## Town and Country Planning Act 1990 (As Amended) Local Highway Authority (LHA) Response

<b>Application Reference</b>	NC/23/00450/DPA
<b>LHA Reference</b>	
<b>Proposal</b>	New detached 4 bedroom family dwelling house.
<b>Location</b>	57 Kirby Road Gretton North Northamptonshire NN17 3DB
<b>Case Officer</b>	Fernando Barber-Martinez
<b>Date Sent</b>	30/11/2023

Drawing Title:
Proposed Plans

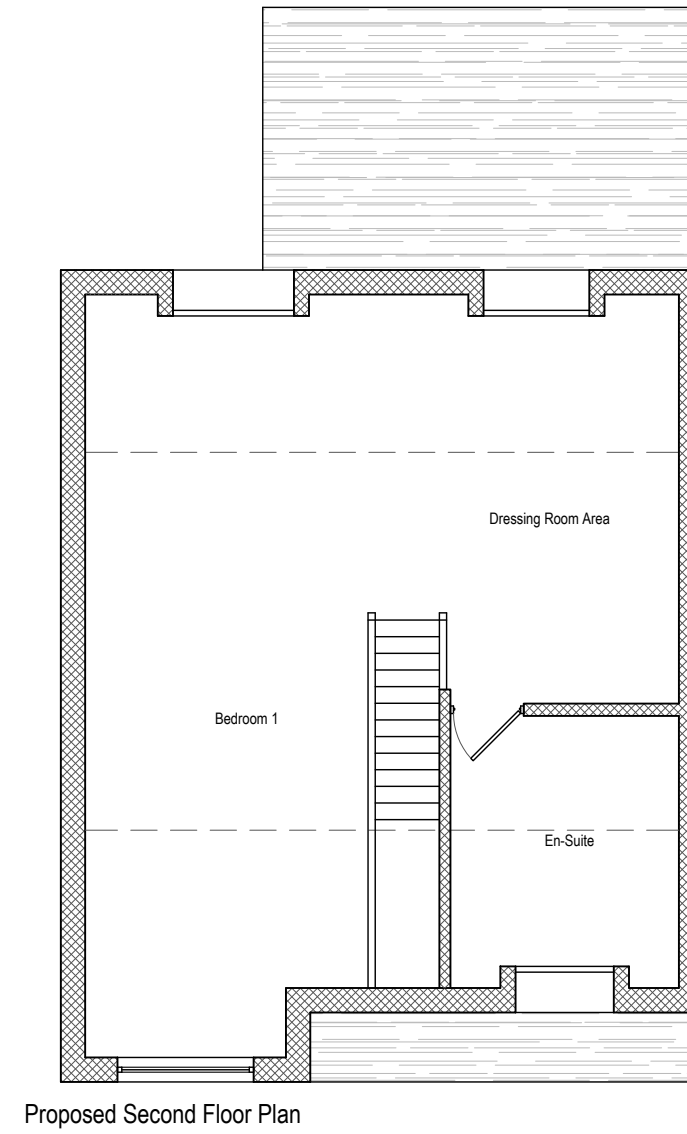
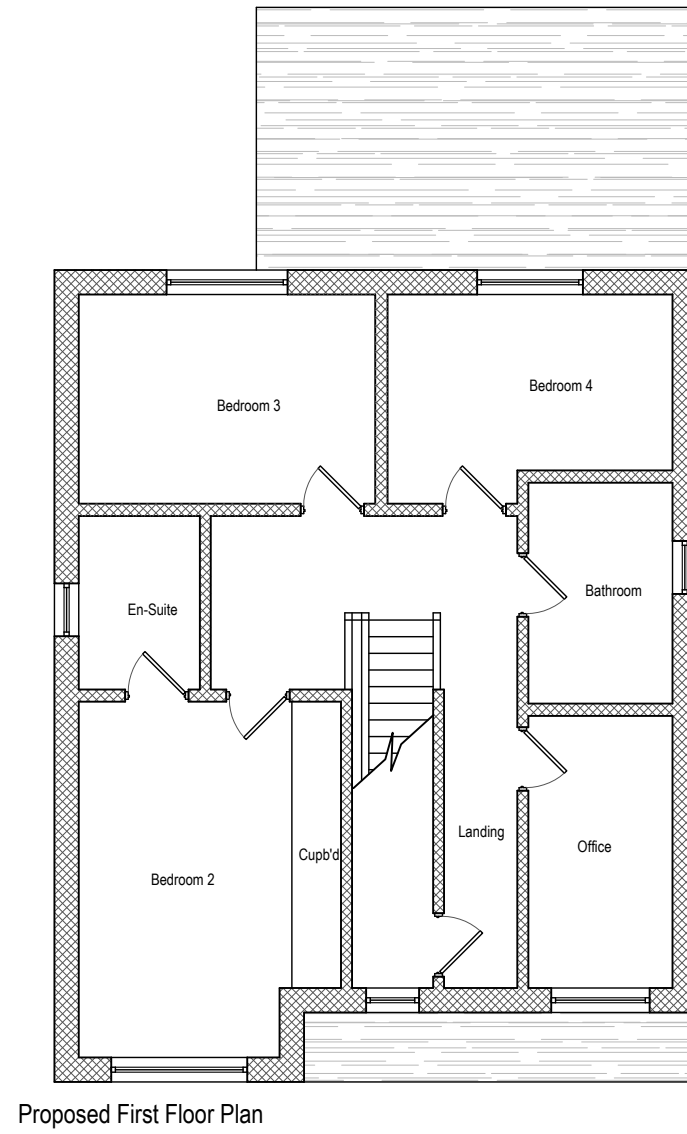
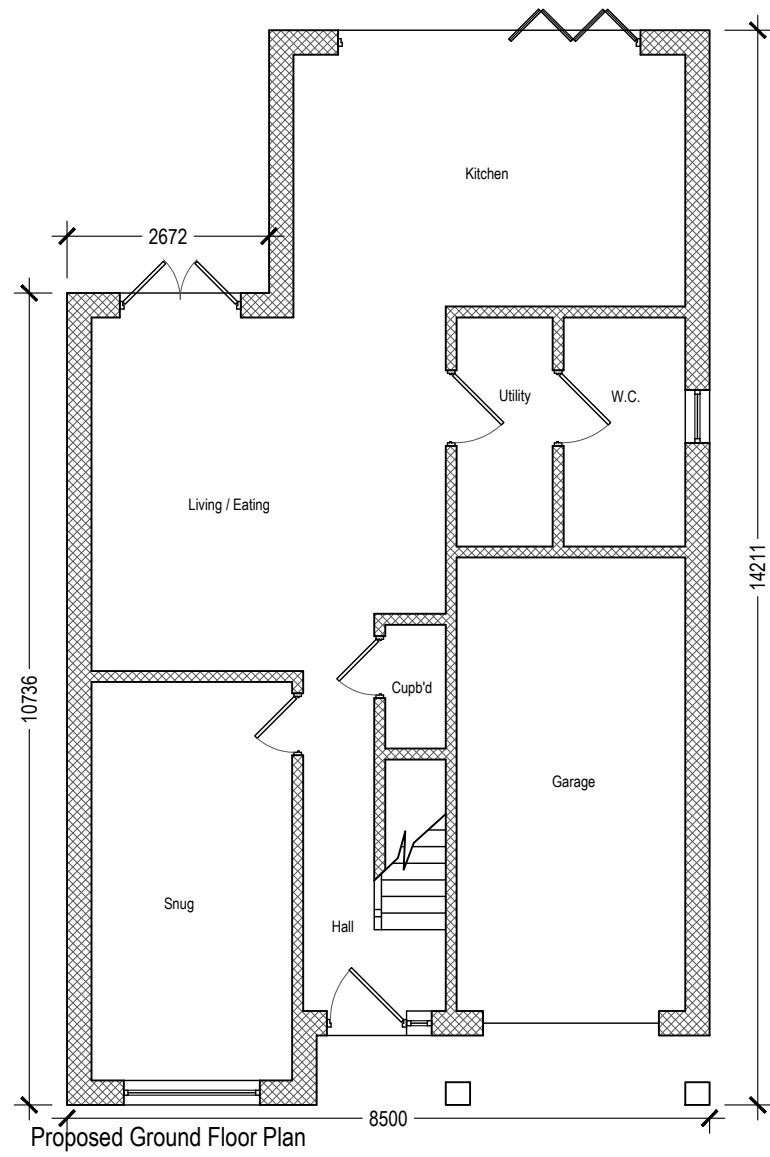
8. Whilst a garage can count as the third parking space for 4+ bed dwellings, they must have minimum internal dimensions of 3.3m wide and 6m long clear of piers/openings.

9. The application form states 4 cycle parking spaces are provided yet none are detailed. They cannot be in the garage as this appears to be proposed as the third car parking space required for a dwelling of this size. If cycle storage is to be in the garage, then the third car parking space must be external.

Block Plan 1:500

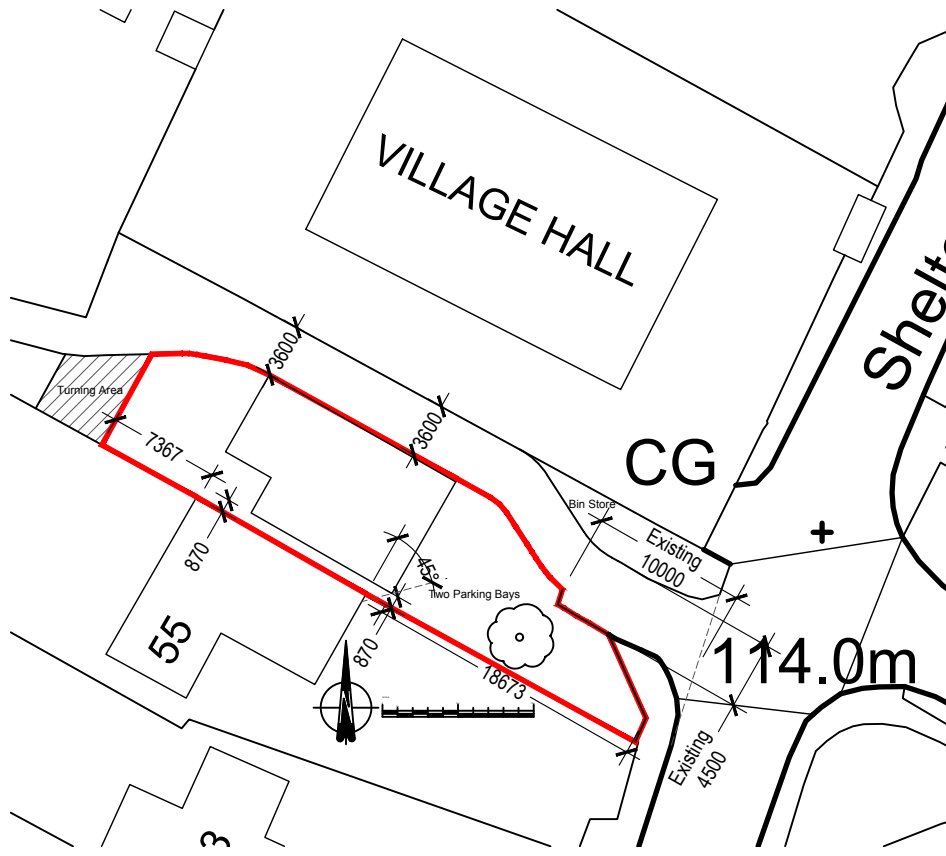
1. The dwelling would appear to be accessed via a shared private drive off Kirby Road. As such, the LHA require confirmation as to the number of dwellings currently served off the shared private drive. In line with adopted policy, the maximum number of dwellings permissible to be served off a shared private drive is 5 (this is defined by the access to the car parking for a maximum of 5 dwellings).

2. A shared private drive must maintain a minimum width of 4.5m for the first 10m from the highway boundary. Across this distance, the drive must also be of a hard bound surface and have a gradient not in excess of 1 in 15. This must be detailed on an accurate and scaled plan.

3. A means of drainage across the back of the highway boundary (linear drain), across the proposed site access draining to soakaways contained within the applicant's own land is required. It is unlawful for surface water to drain from private property onto the public highway. This must be detailed on an accurate and scaled plan.

4. Pedestrian visibility splays of at least 2.0m x 2.0m are required on each side of the vehicular access. These measurements are taken from and along the highway boundary. The splays shall thereafter be permanently retained and kept free of all obstacles to visibility over 0.6m in height above access / footway level. The land should be contained entirely within land in the control of the developer. These must be detailed on an accurate and scaled plan.

5. Vehicular visibility splays of 2.0m from the carriageway edge along the centre of the vehicular access by a distance of 43m measured from the centre of the vehicular access along the carriageway edge. The splays shall thereafter be permanently retained and kept free of all obstacles to visibility over 0.9m in height above carriageway level. These must be detailed on an accurate and scaled plan.

7. Car parking spaces should be 3m wide by 5m long (widened to 3.3m where adjacent to a solid side boundary). They must be clearly detailed on an accurate and scaled plan also bearing in mind a minimum of 6m clear space is required to their rear for safe egress.
